RESPONSE TO SUBMISSIONS

S4.55(2) AMENDMENT OF INSTRUMENT OF APPROVAL MP 09_0121

47-50 THE ESPLANADE, ETTALONG BEACH

**LEVEL 03  
FLOOR PLAN**

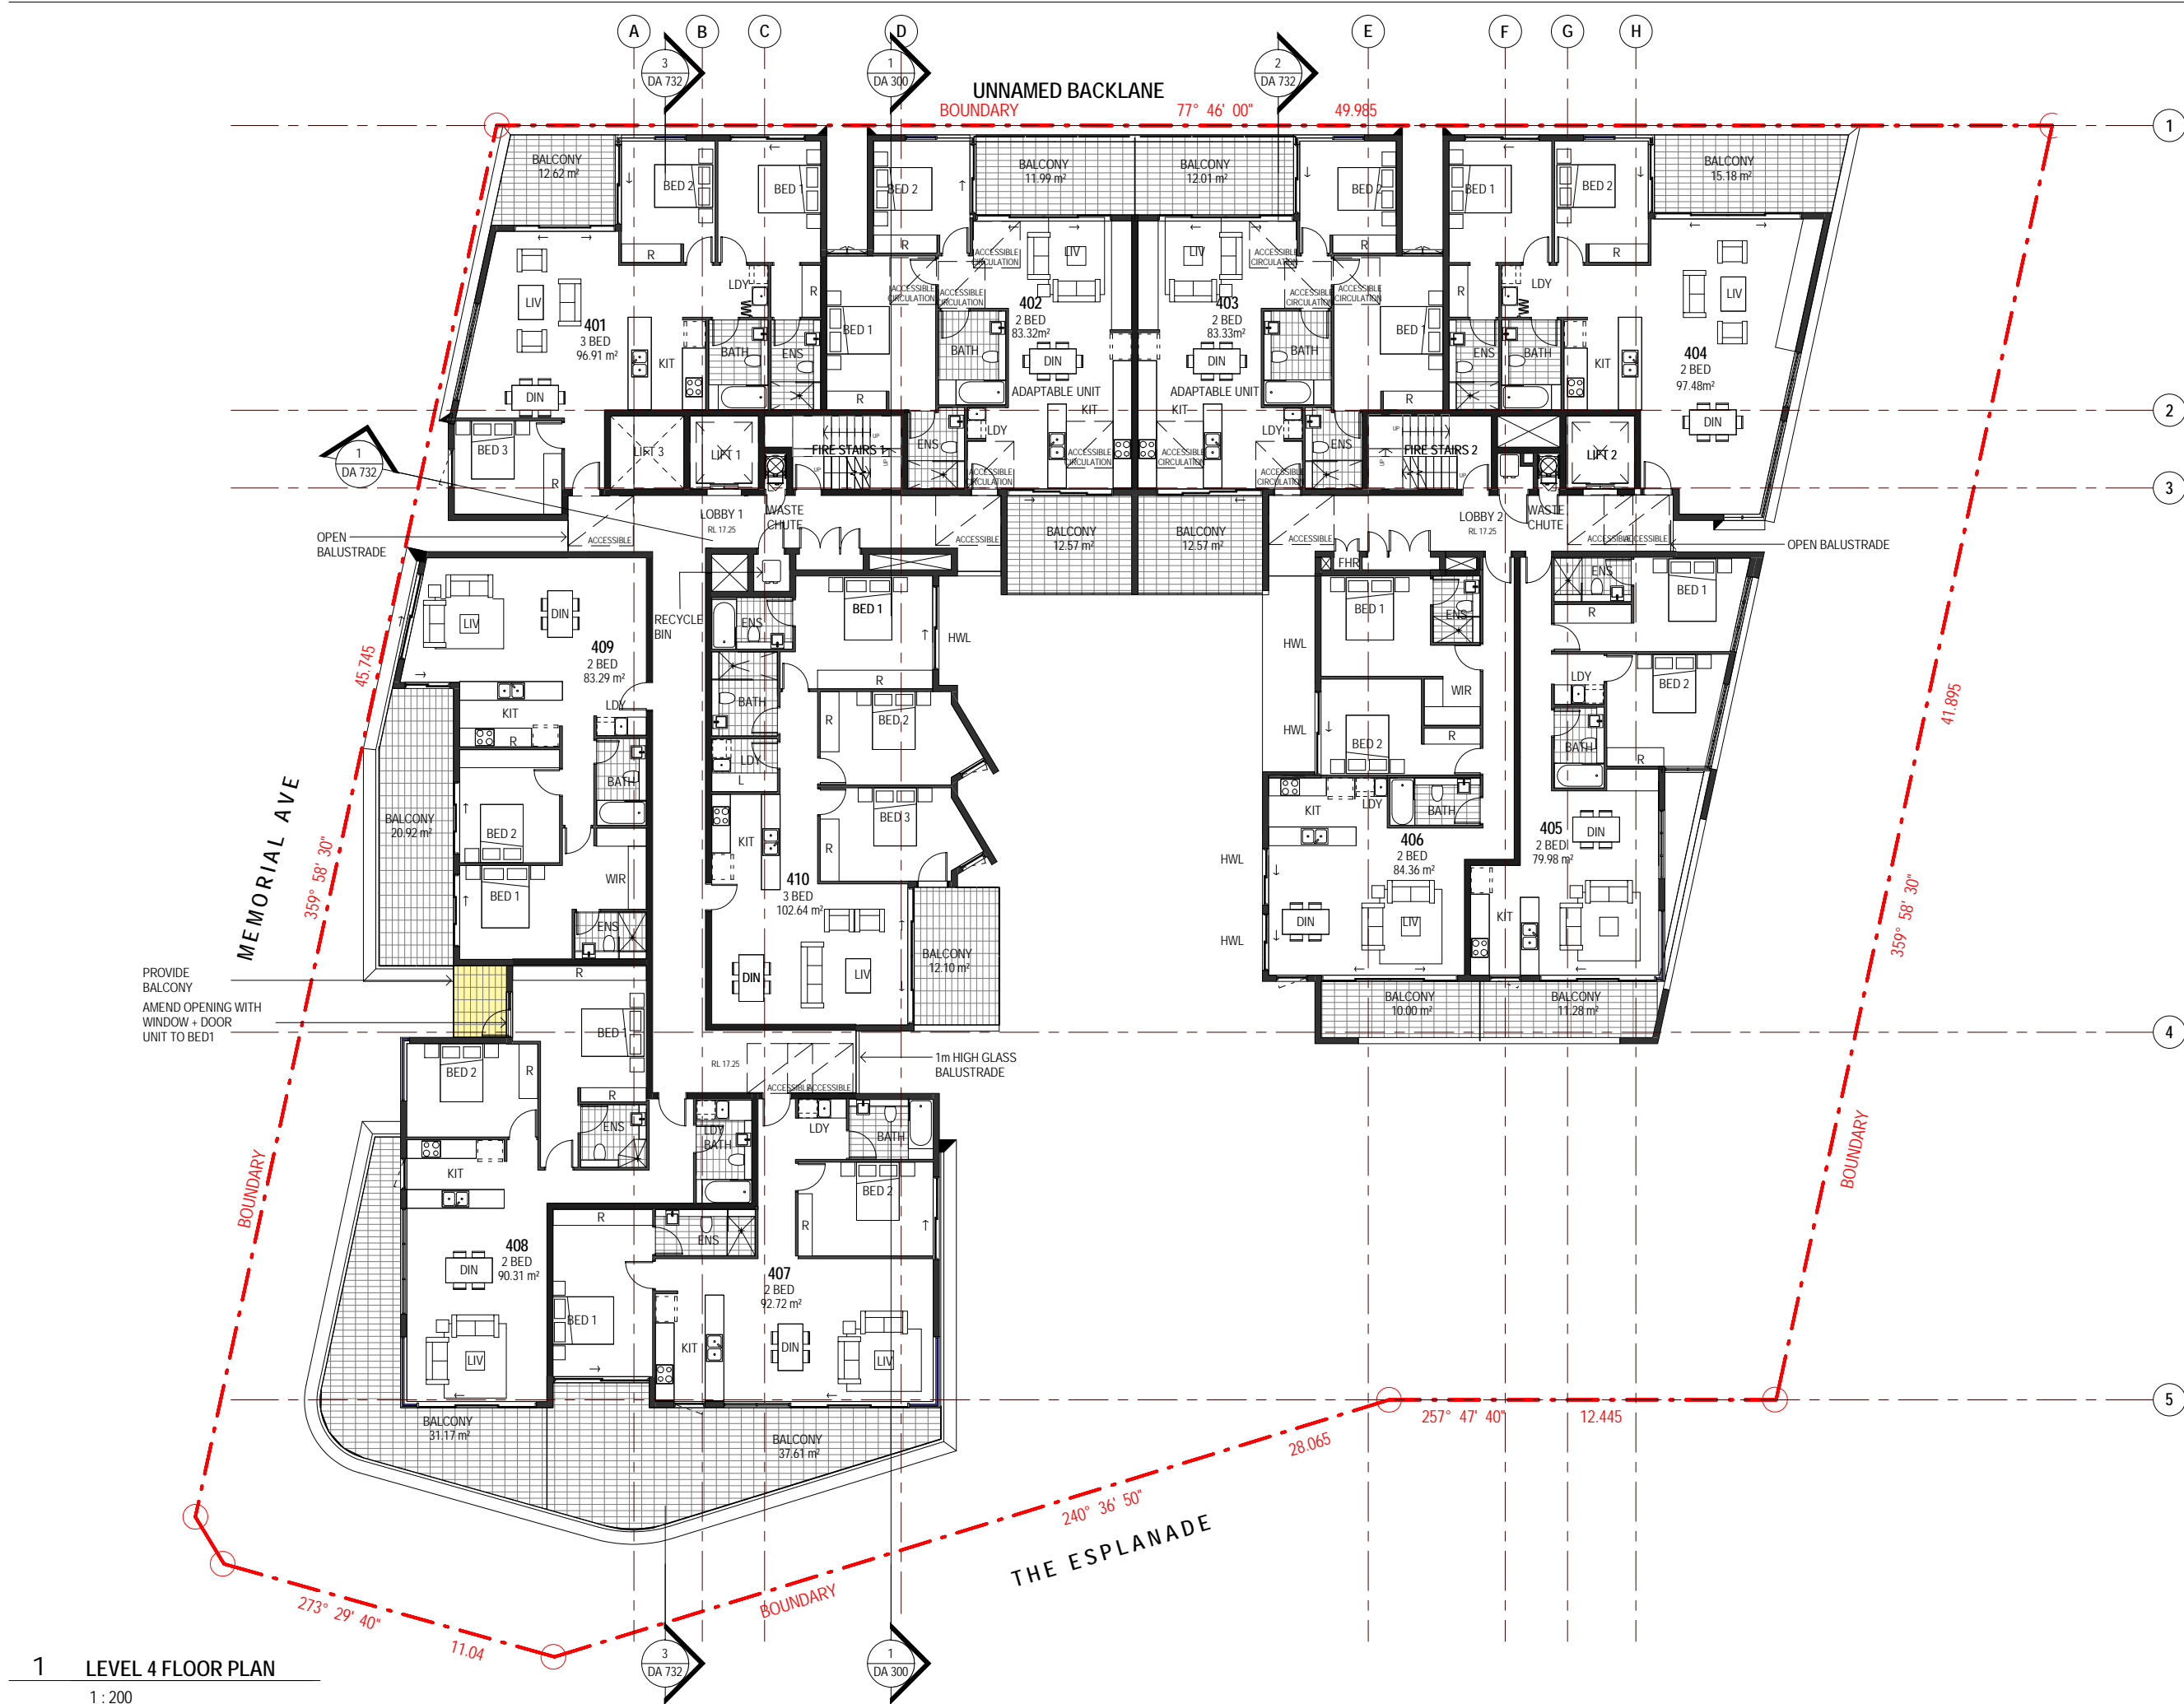
- The potential for noise nuisance to arise from the use of larger and additional balconies and a roof terrace.
- Visual privacy concerns associated with the locations of proposed balconies and roof terrace facing towards the Mantra Resort.
- Visual Impact arising from various aspects of the proposal, especially relating to the proposed level 3 and 5 privacy screens, modified balustrades and the roof terrace.

Level 3 and 5 extended balconies

The extensions to the Level 3 and Level 5 balconies are oriented towards the ocean views to the south and south-east. The Mantra Resort sits to the north-west of the extended balconies. As a result, any views towards the balconies of the Mantra Resort will be incidental rather than primary. Incidental views towards the Mantra Resort are already possible under the approved development. The extension of these balconies does not significantly increase the privacy impacts upon the eastern apartments of the Mantra Resort.

- Sections of the balconies on levels 3 and 5 for apartments 307, 308, 506 and 507 are now to be non-trafficable.
- The extent of privacy screens on levels 3 and 5 are reduced.
- The new glass balustrades to levels 3 and 5 are to be frameless balustrades with clear glass.
- The roof area is no longer proposed to be modified to be trafficable.

- Sections of the balconies on levels 3 and 5 for apartments 307, 308, 506 and 507 are now to be non-trafficable.
- The extent of privacy screens on levels 3 and 5 are reduced.
- The new glass balustrades to levels 3 and 5 are to be frameless balustrades with clear glass.

Due to the reduced length of the privacy screens on levels 3 and 5 and revised the balustrades to frameless glass, the impact from these structures will be minimal when viewed at a distance of over 18m as from the Mantra Resort. The frameless glass is entirely transparent and will result in minimal disruption of views. The reduction of the trafficable area of the balconies minimises the potential for occupants to place items on the balconies which may obscure views.

Drawing Title  
**ROOF PLAN**

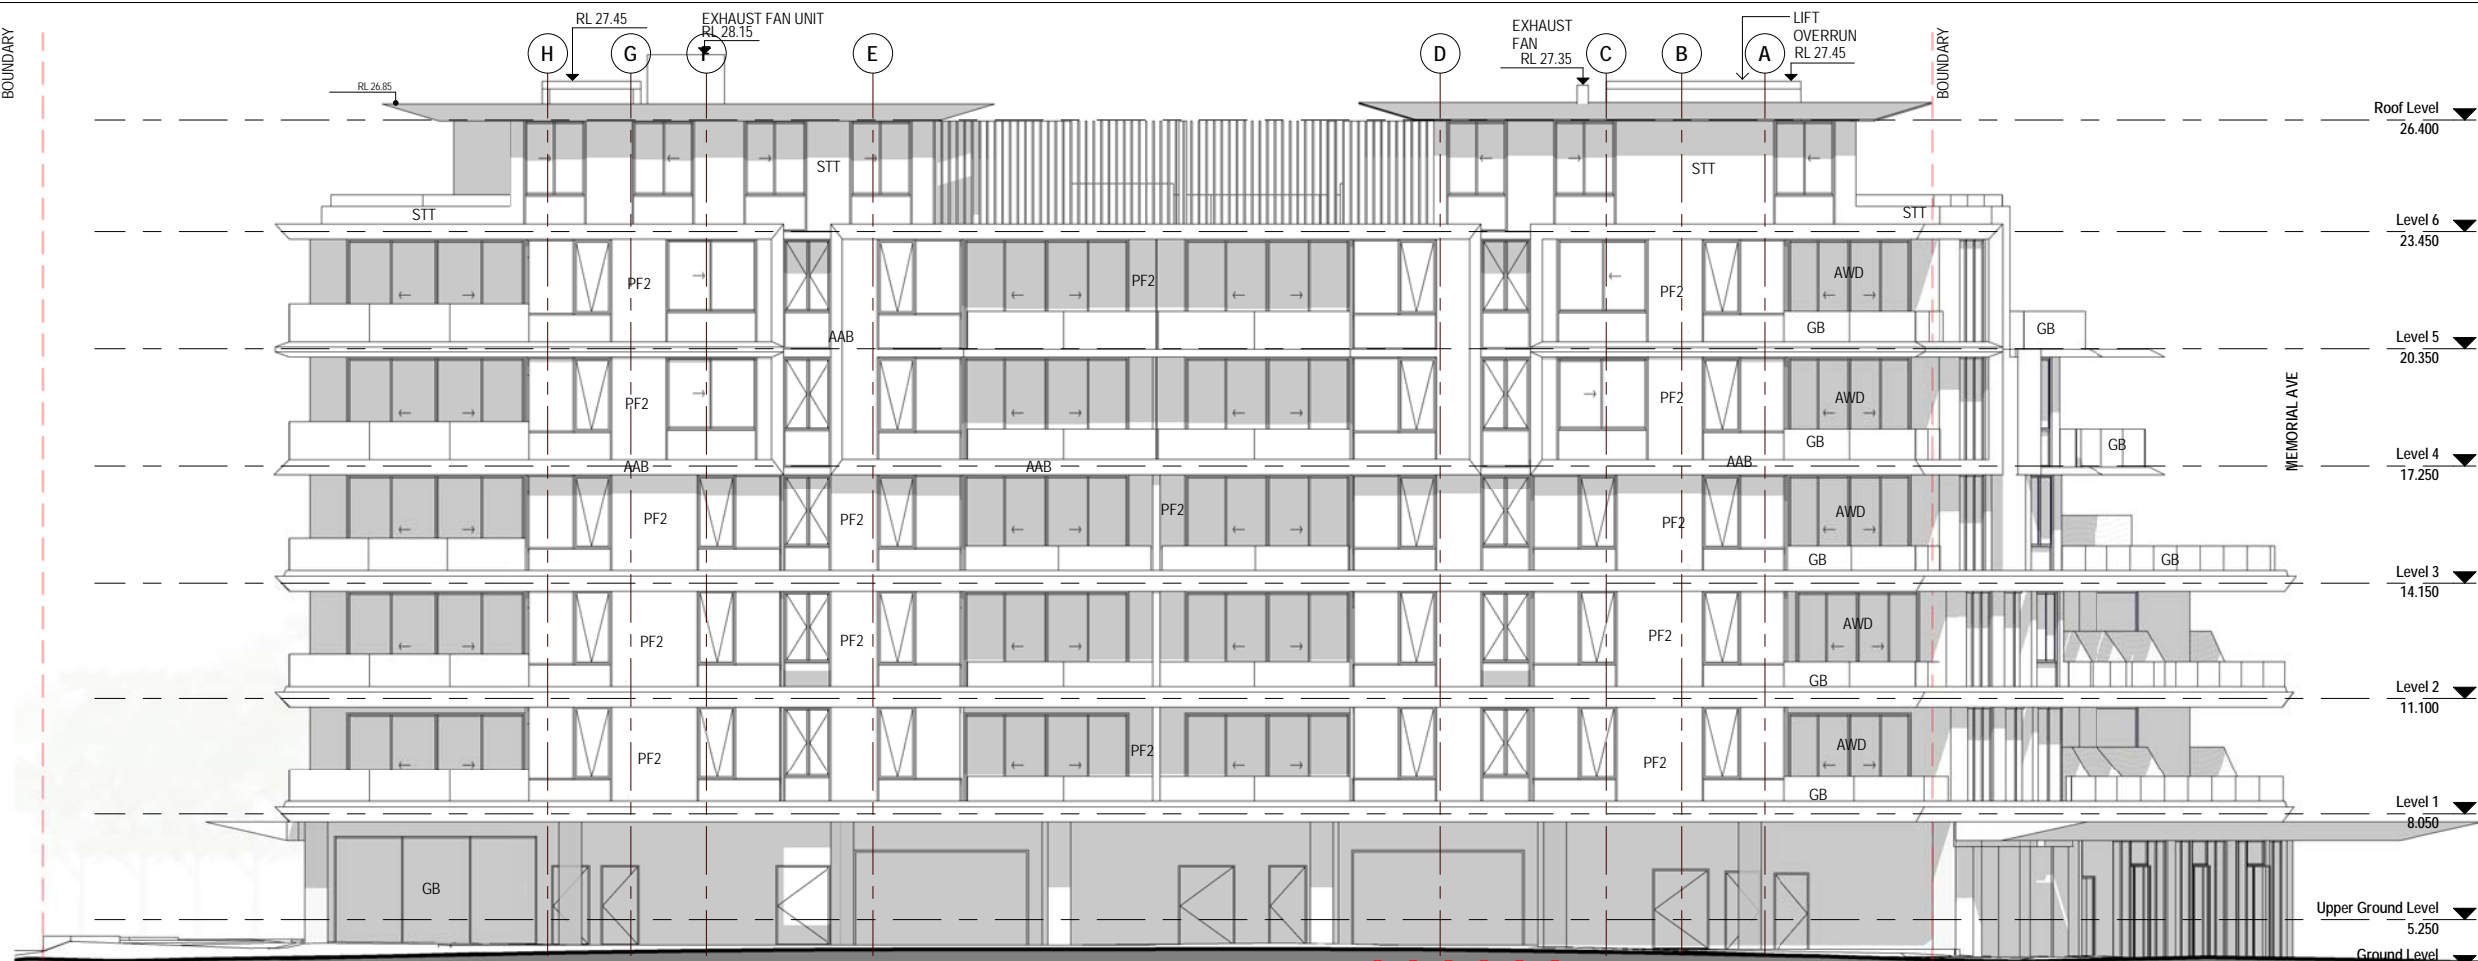
Visual privacy concerns were raised in several submissions by Mantra Resort residents. These concerns related to all new and extended balconies on the western elevation and the trafficable roof terrace. The trafficable roof terrace has been entirely removed in the revised proposal.

Submissions regarding visual impact are primarily related to the balustrades and privacy screens proposed for the extended balconies on Levels 3 and 5 and the proposed roof terrace. The proposed roof terrace has been removed in the revised proposal and is no longer a relevant consideration.

The submissions concerning noise impacts rely on unfounded assumptions regarding the use of the balconies for parties and other similar events. While these assumptions are entirely speculative and unfounded, it should be noted that the proposal has been revised to reduce the proposed trafficable area of the balconies on levels 3 and 5 and to entirely remove the trafficable roof terraces from the proposal.
